**Subject: Canal Landing New Yard – Phase 1**  
**40 West Commercial Street**  
**Applicant: New Yard, LLC**  
**Condition Compliance Letter #1**

On behalf of New Yard, LLC, we are pleased to provide evidence of compliance with the City of Portland Planning Board's Conditions of Approval #4, 6 and 8 regarding the Final Site Plan Application for Canal Landing project in Portland. For ease of review, conditions of approval are repeated below (*in italics*) followed by our compliance.

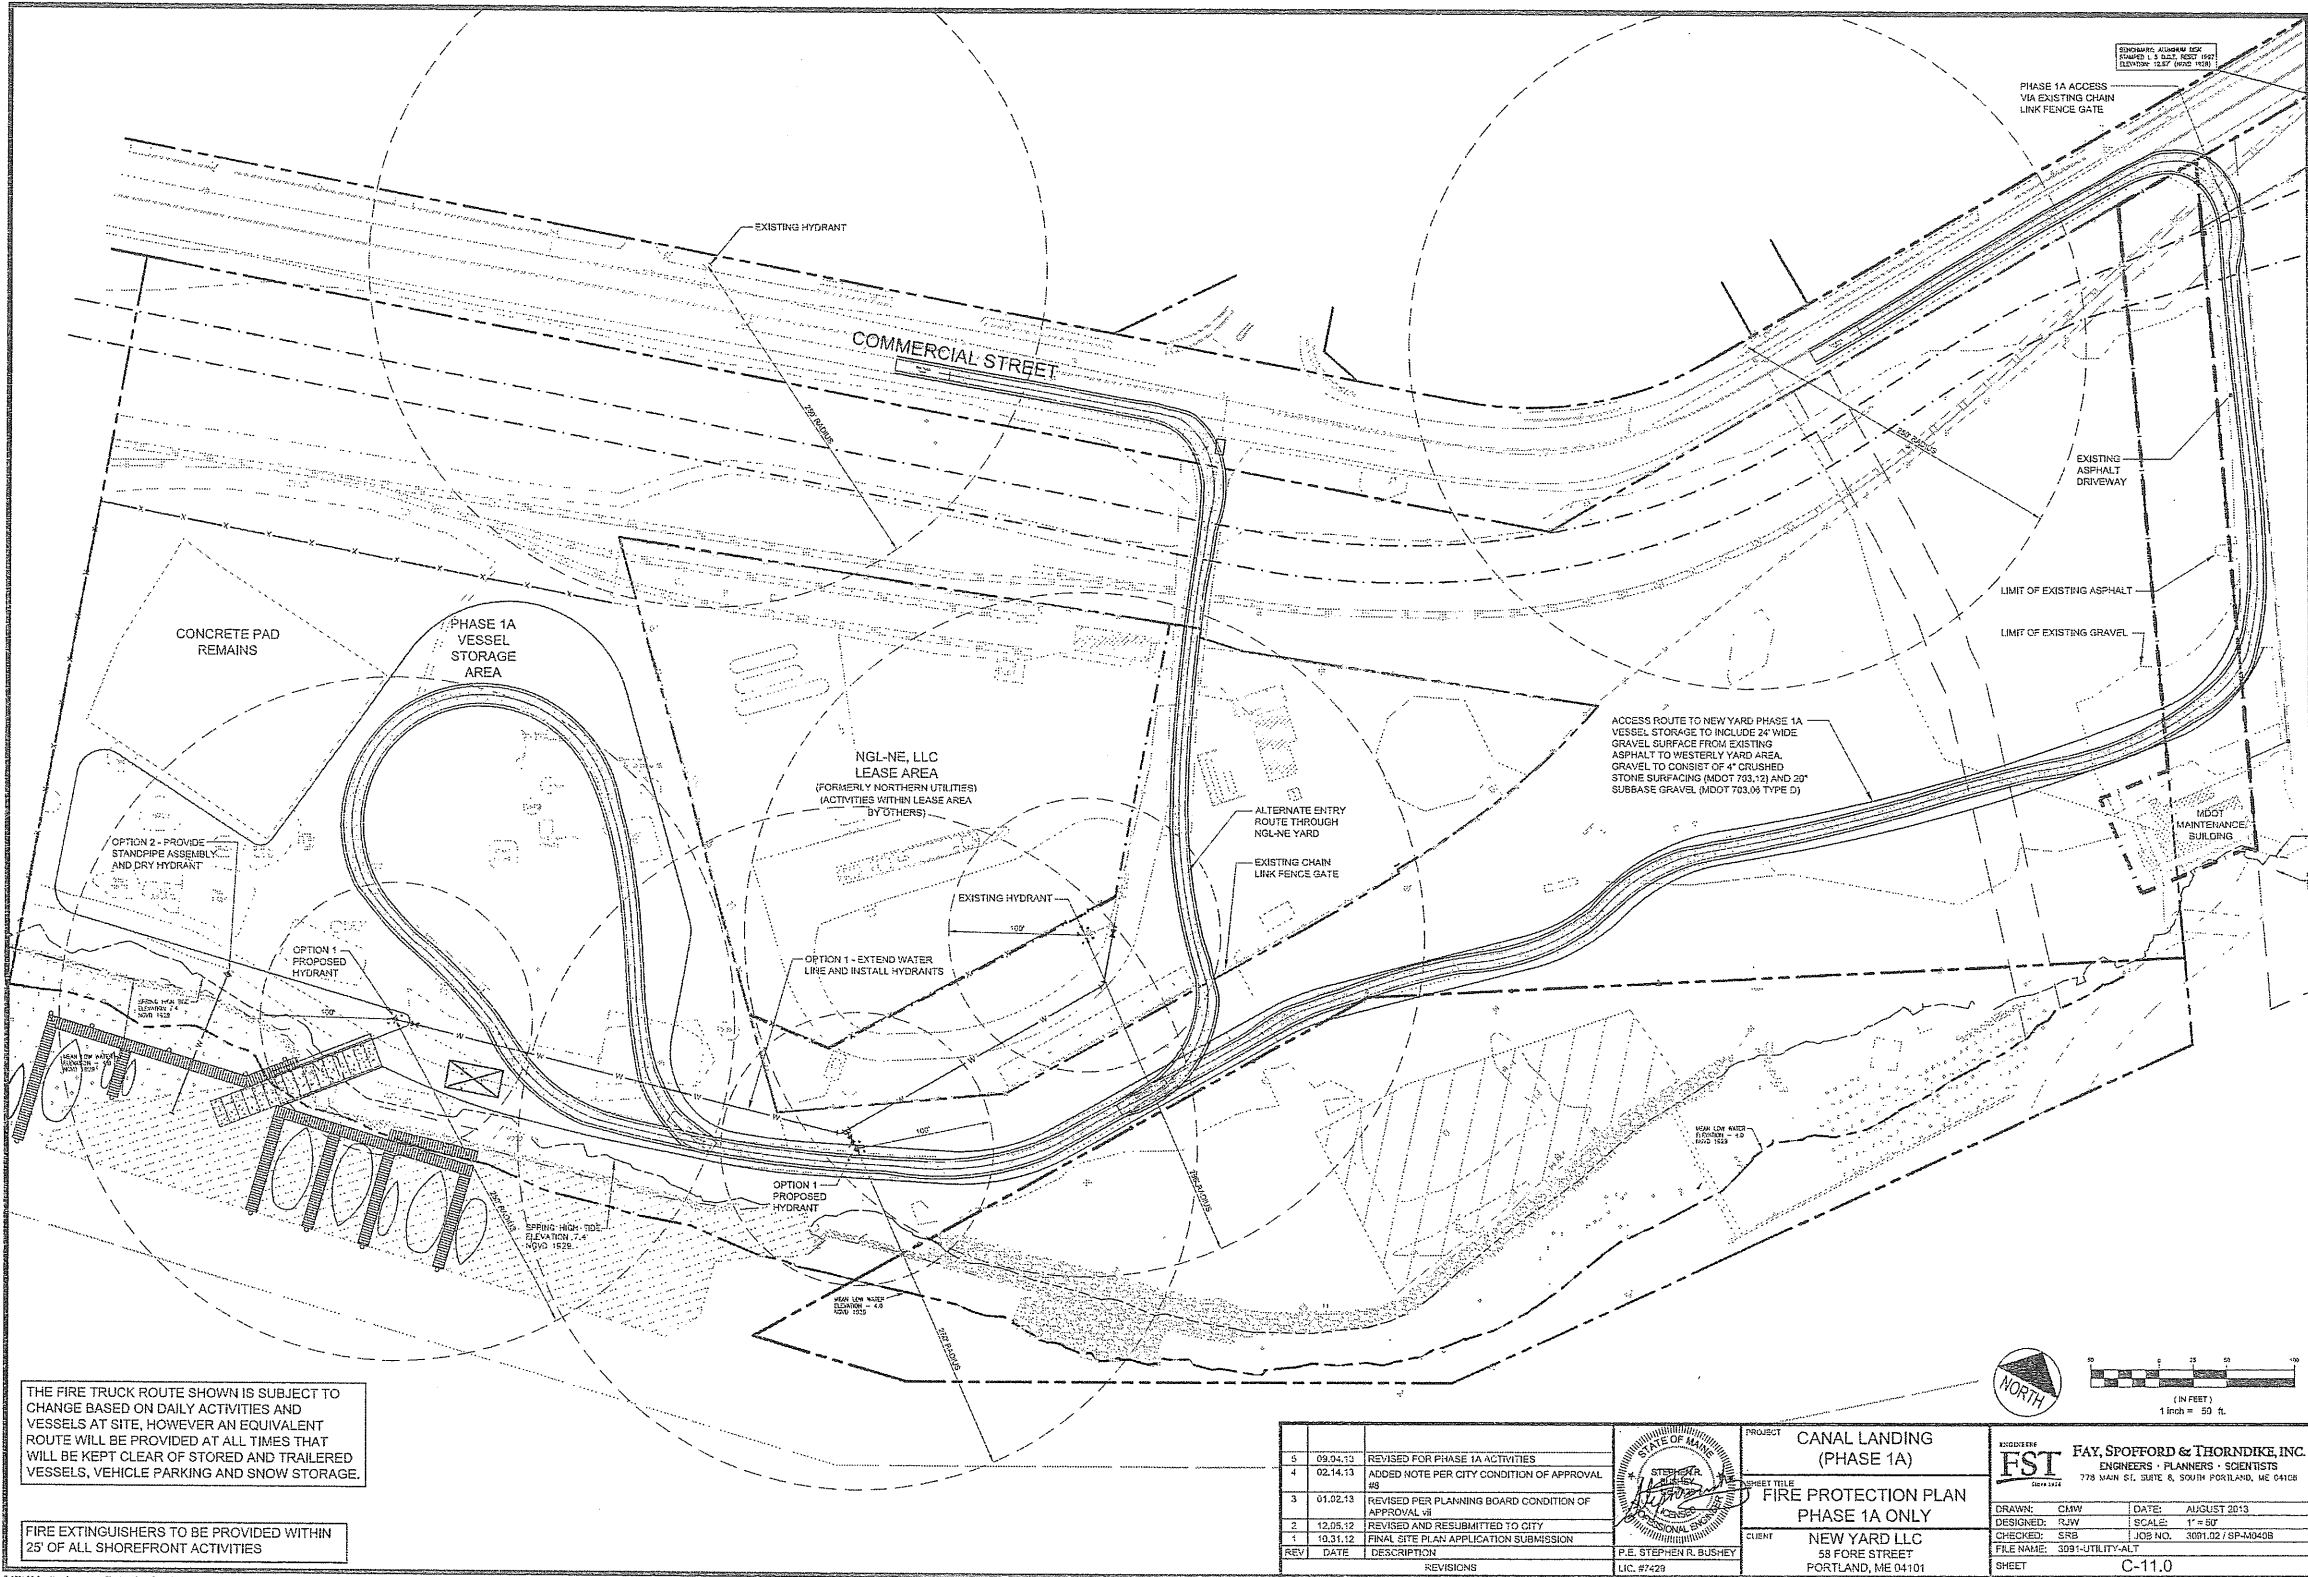
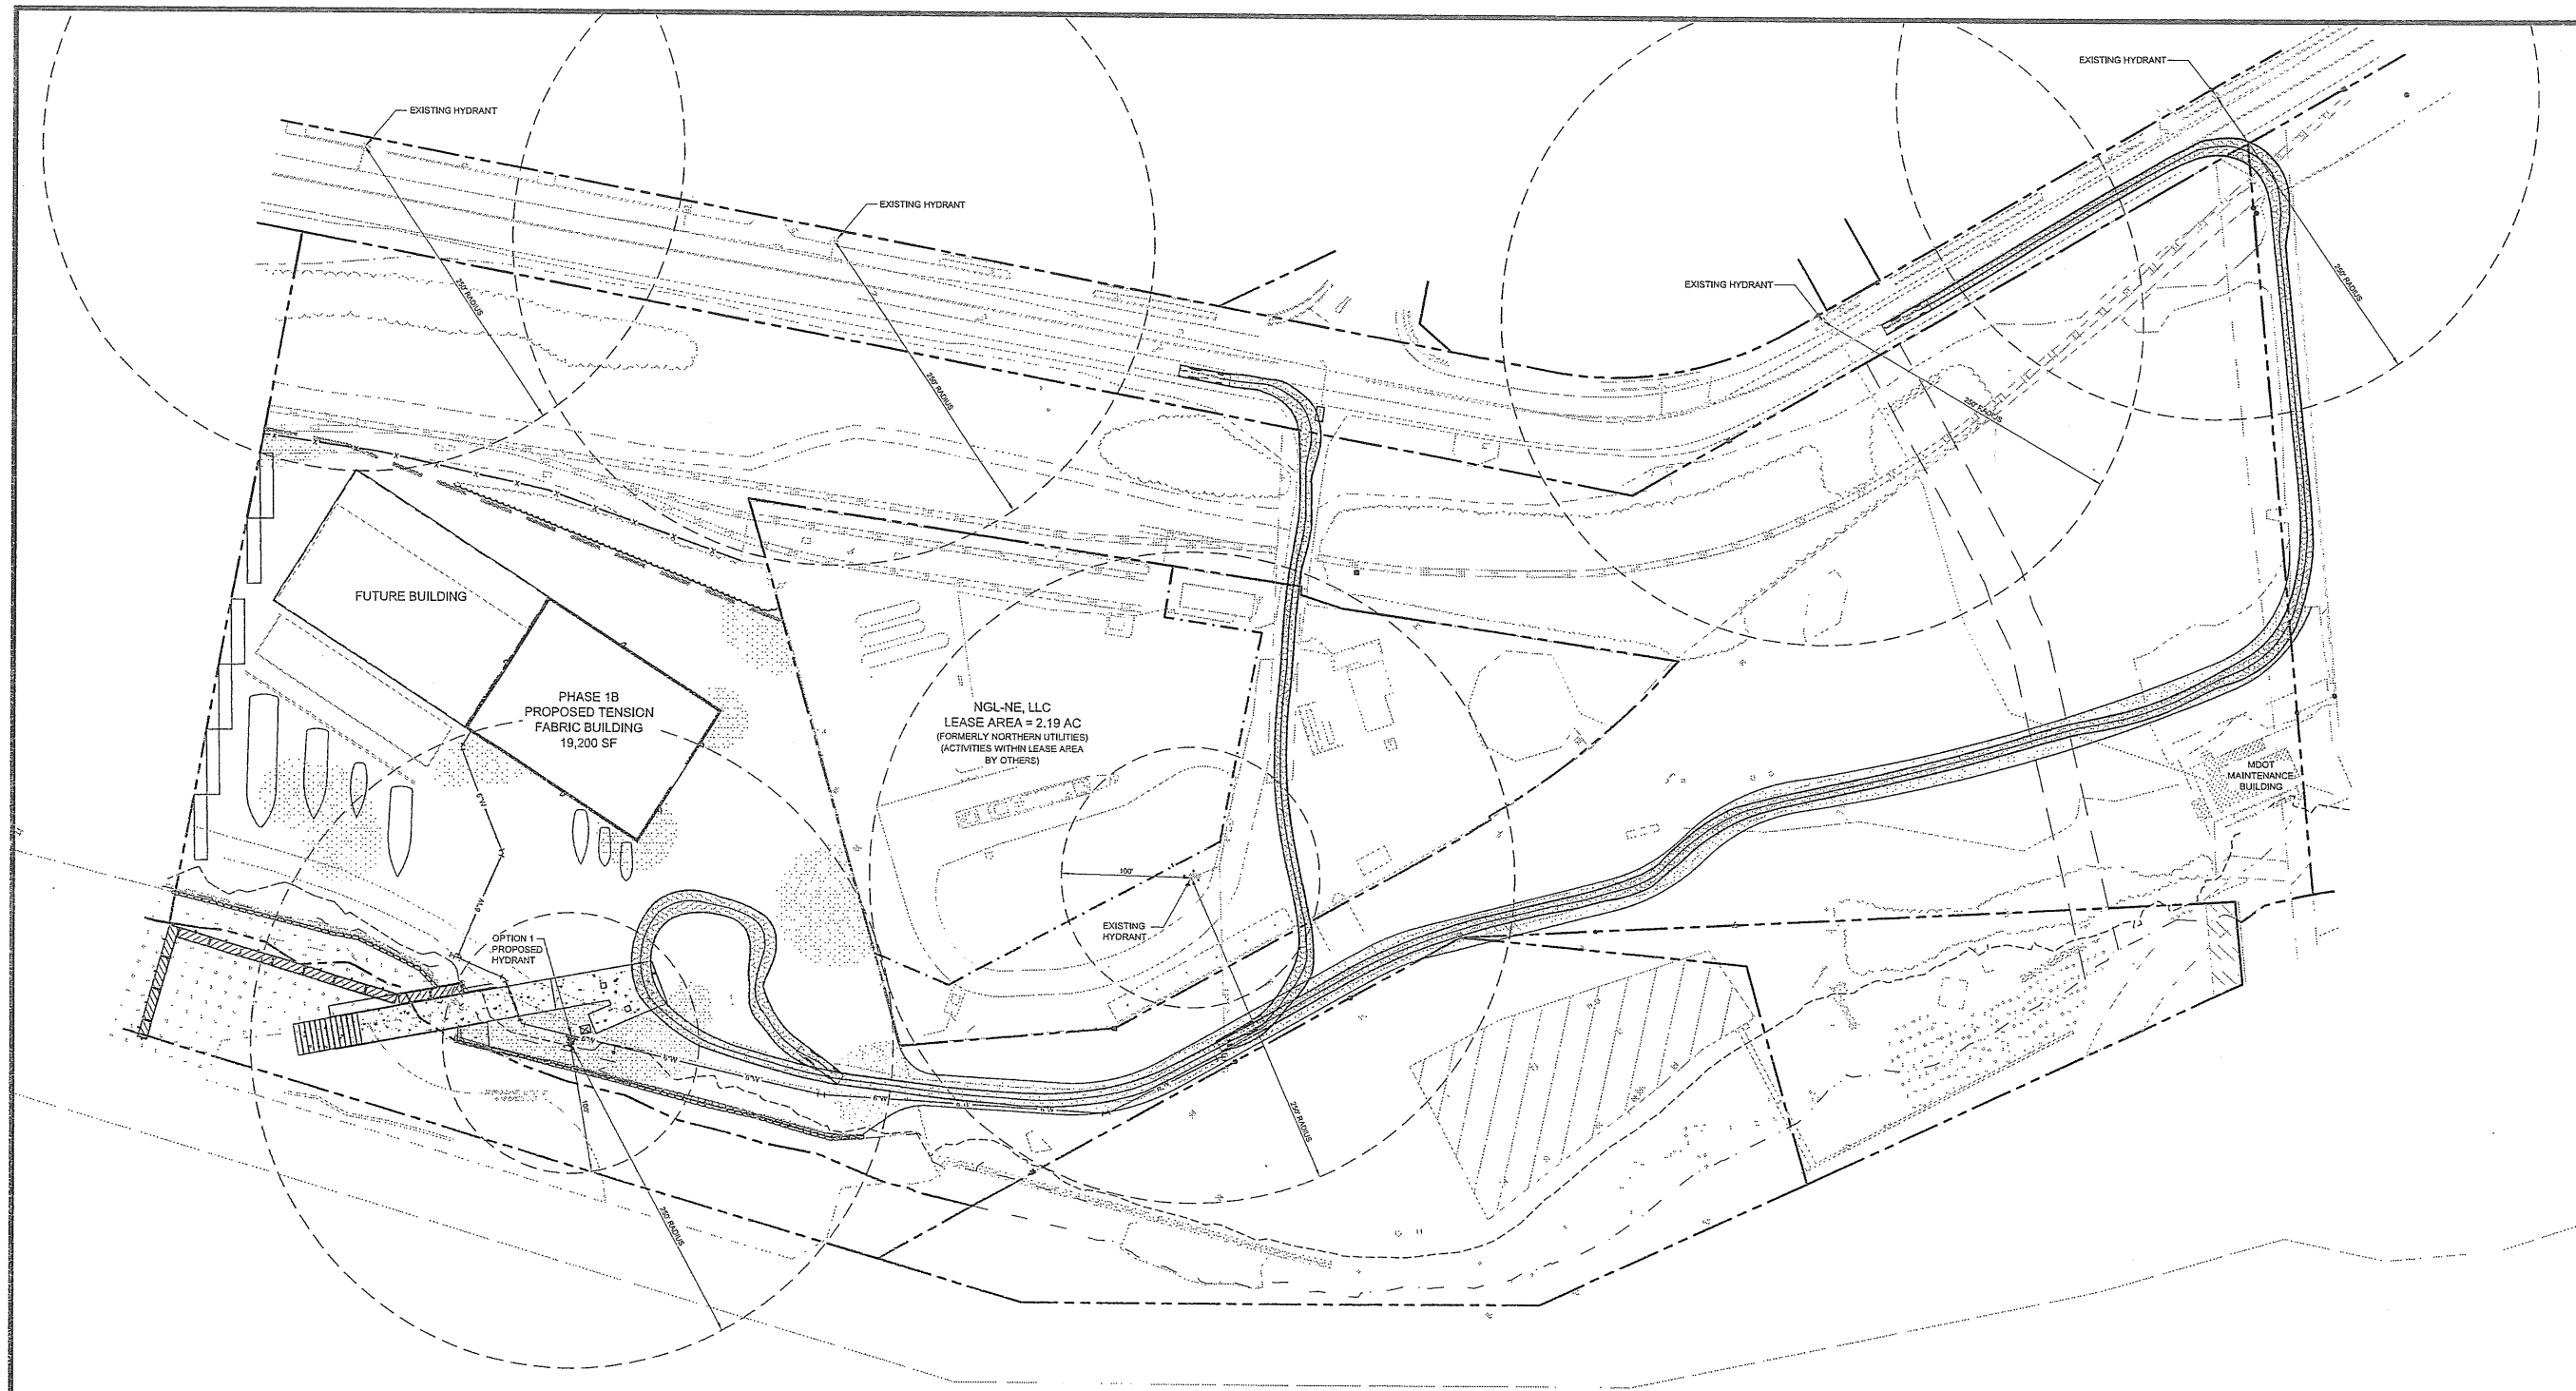
*Fire Safety and Emergency Access: That prior to issuance of a building permit, the applicant submit a revised site plan for review and approval in compliance with the December 12, 2012 fire code analysis memo from Fire Risk Management, Inc. (Attachment U of Planning Report #53-12). The revised site plan will show emergency access routes to be kept clear of stored and trailered vessels, vehicle parking and snow storage.*

Plan C-11.0 – Fire Protection Plan has been added to the plan set. This plan shows fire truck circulation around the site and shows additional hydrants and the coverage radii as recommended by Fire Risk Management, Inc. A copy of this plan accompanies this letter.
